RTA Ref: RDC 10M2551 v2 SYD10/01055
Contact: Owen Hodgson T 8849 2012
DoPI Ref: MP 10_0189

Transport
Roads & Traffic
Authority

**EXHIBITION OF ENVIRONMENTAL ASSESSMENT
ROYAL REHABILITATION CENTRE SYDNEY**

NOTE: CONCEPT INTERSECTION PLAN  
- SIGNALISED ACCESS EAST OF IRVINE  
CRESCENT IS SUBJECT TO RTA APPROVAL

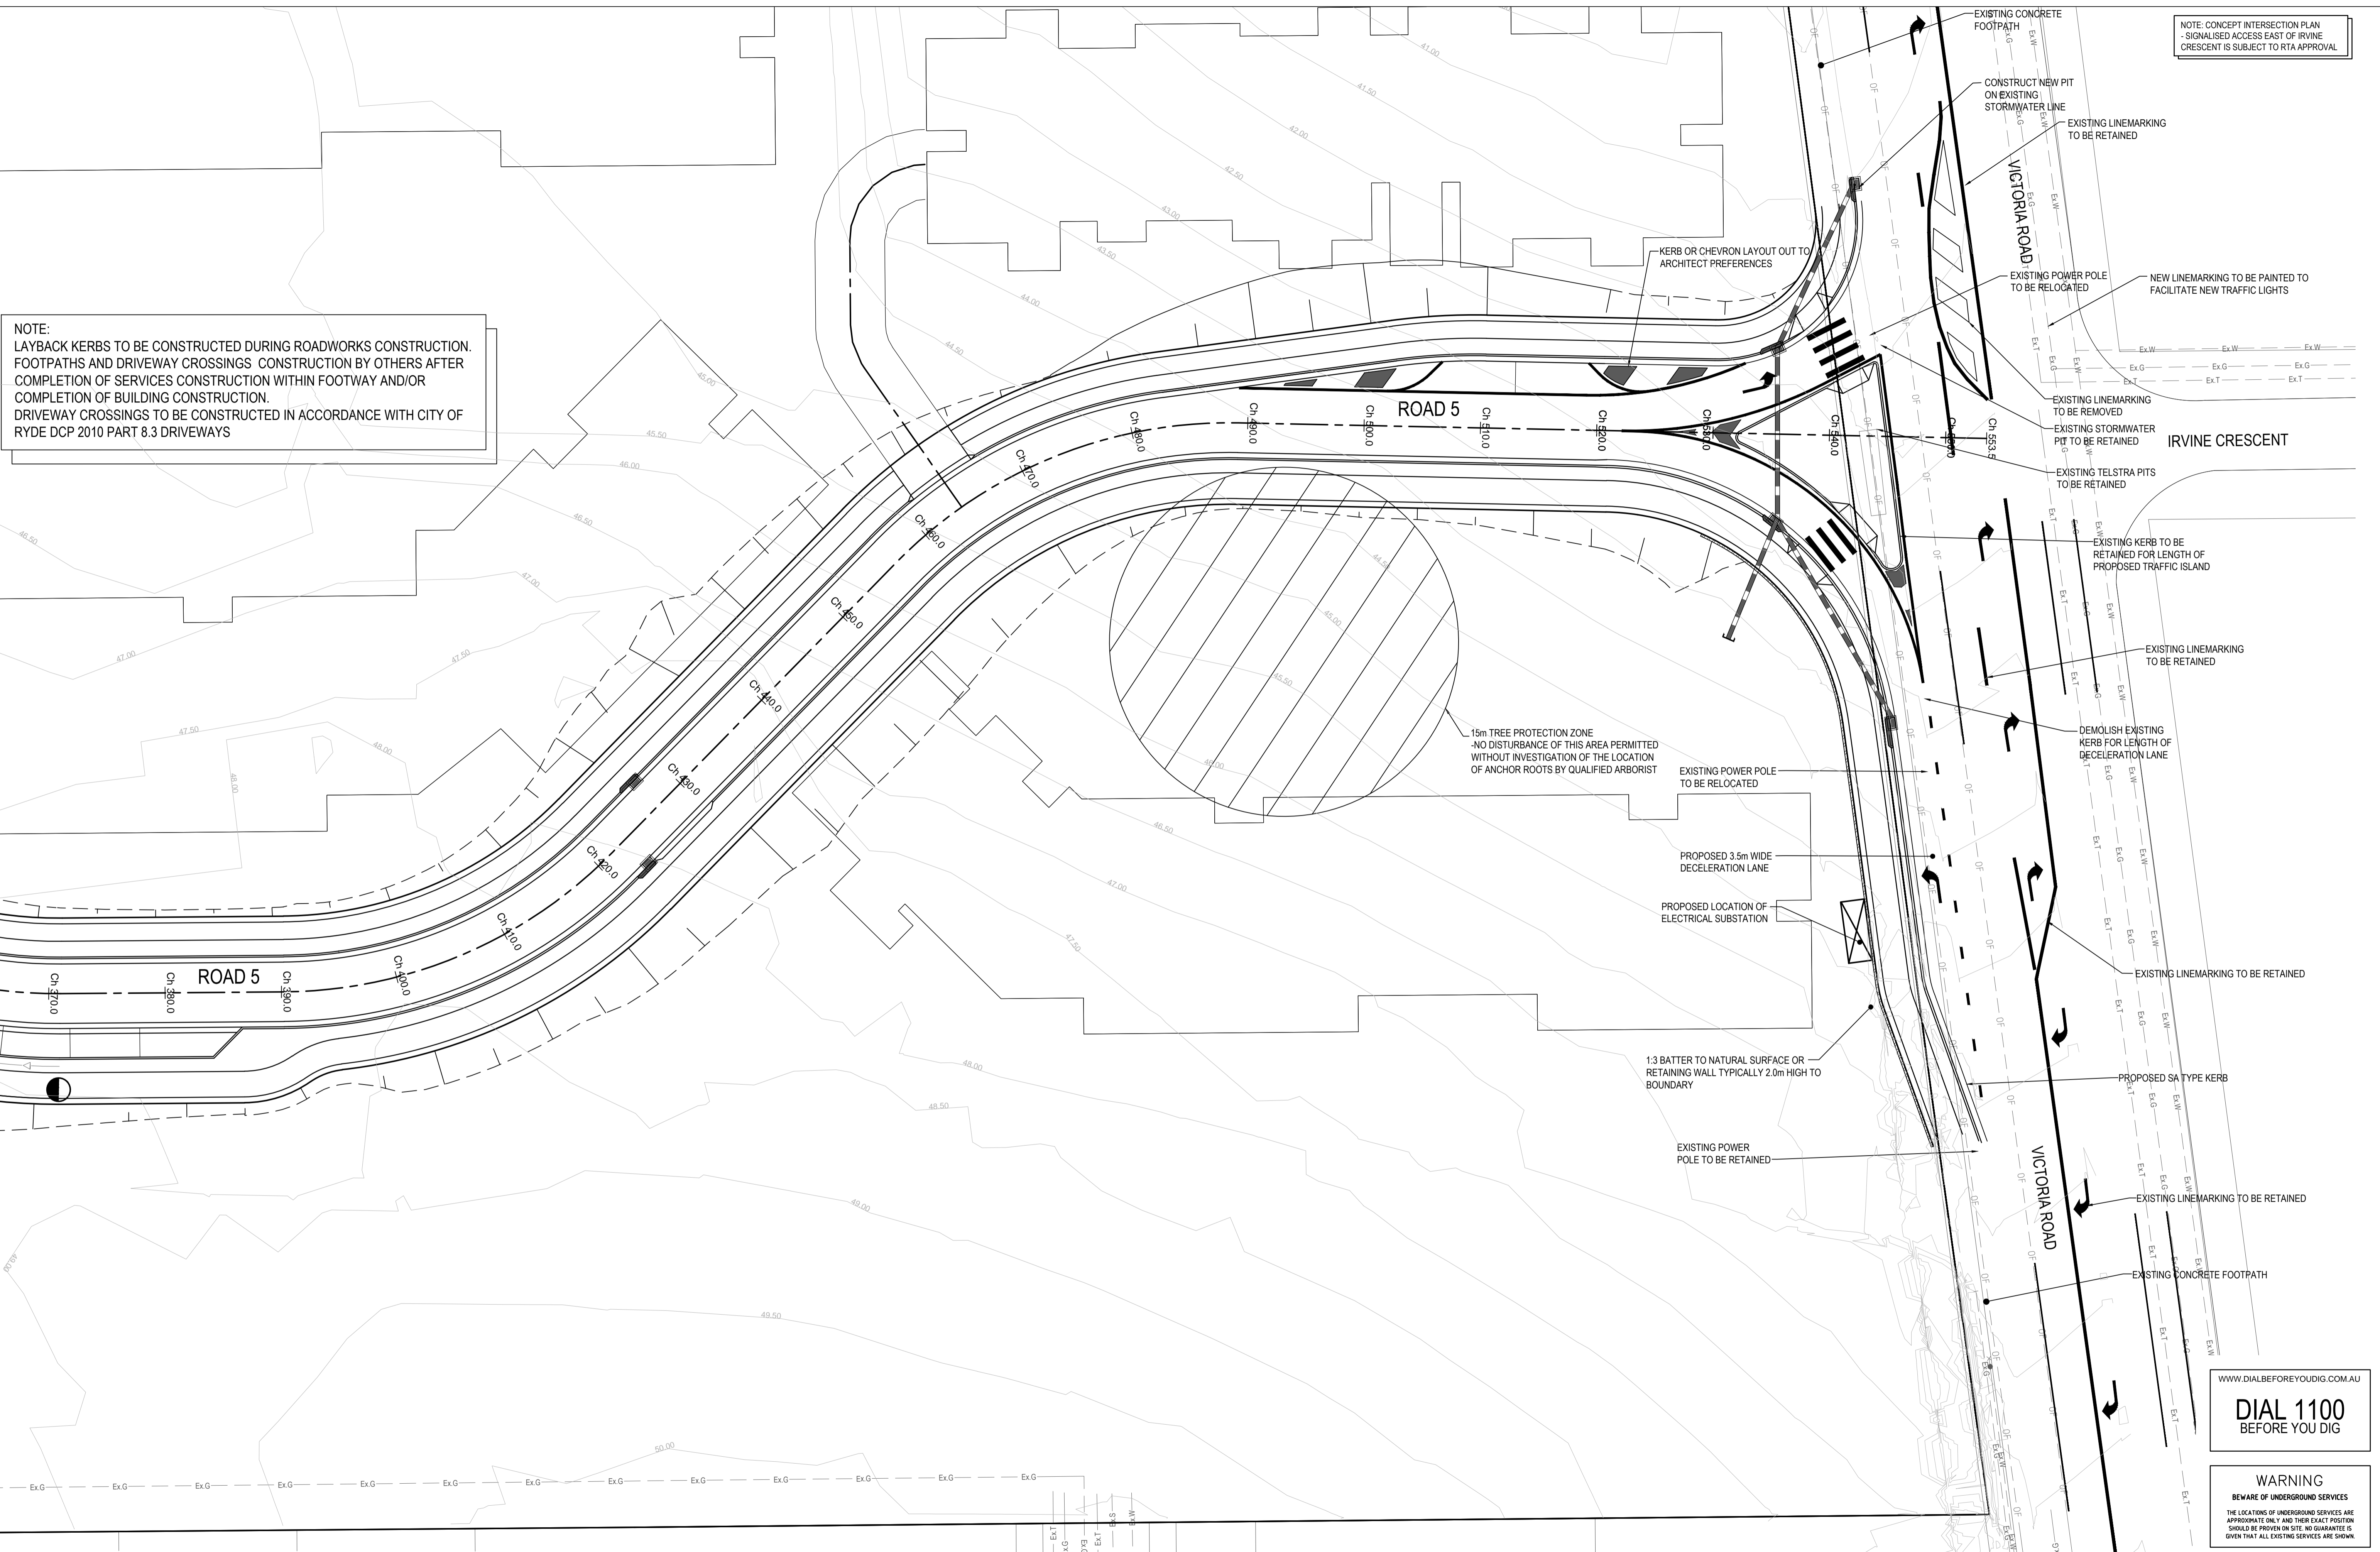
5. The proposed deceleration lane along Victoria Road shall be designed to meet RTA's requirements, and endorsed by a suitably qualified and chartered Engineer (i.e. who is registered with the Institute of Engineers, Australia).

Please note the RTA does not support signals at Site Access/Irvine Crescent/Victoria Road intersection for reasons outlined in letter dated 9 May 2011 forwarded to the Department of Planning and Infrastructure.

The design requirements shall be in accordance with Austroads Guide to Road Design in association with relevant RTA supplements (available on www.rta.nsw.gov.au). The certified copies of the civil design plans shall be submitted to the RTA for consideration and approval prior to the release of construction certificate by the appointed Private Certifier or Council and commencement of road works.
